RE: DOSIER SHORT PLAT, File Number SP-07-46

Kittitas County Community Development Services has determined that the Dosier Short Plat is a complete application and hereby grants **conditional** preliminary approval subject to the following conditions:

**CRUSE & ASSOCIATES**  
PROFESSIONAL LAND SURVEYORS  
217 E. Fourth St. P.O. Box 959  
Ellensburg, WA 98926 (509) 962-8242  
**DOSIER SHORT PLAT**

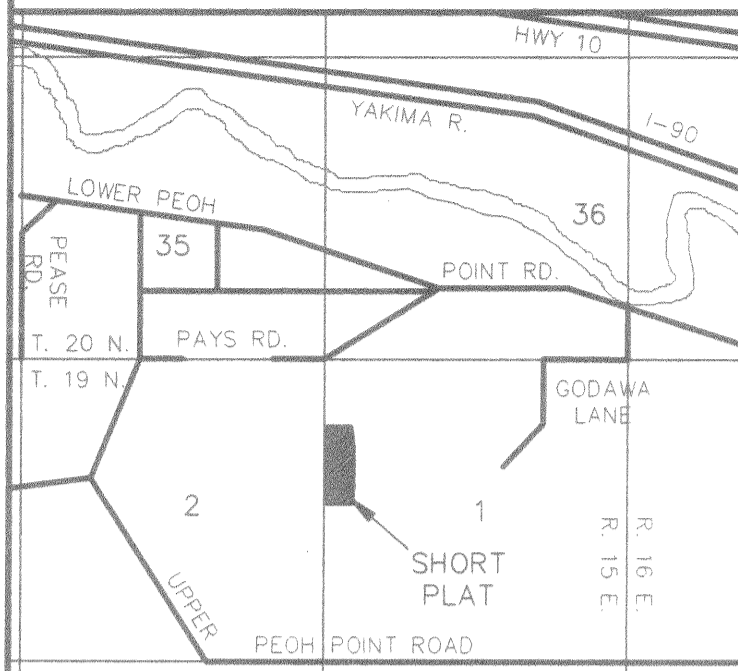
1. Both sheets of the final mylar shall reflect the short plat number **SP-07-46**.
2. All conditions set forth in the KRD General Guidelines for subdivisions will need to be met prior to final approval.
3. A statement regarding drainage improvements for the proposed subdivision shall be on the final mylars.
4. All access roads shall be clearly depicted and labeled in the vicinity map of the final mylars.
5. Refer to Kittitas County Code Title 16 for requirements for final plat submittal. Final mylars shall be submitted per KCC 16.20: Final Plats.
6. All development of the subject parcels shall be in accordance with the requirements of the road variance developed for this project by Kittitas County Public Works.
7. The final mylars shall contain the following plat note:
 - "All development must comply with IFC fire code.
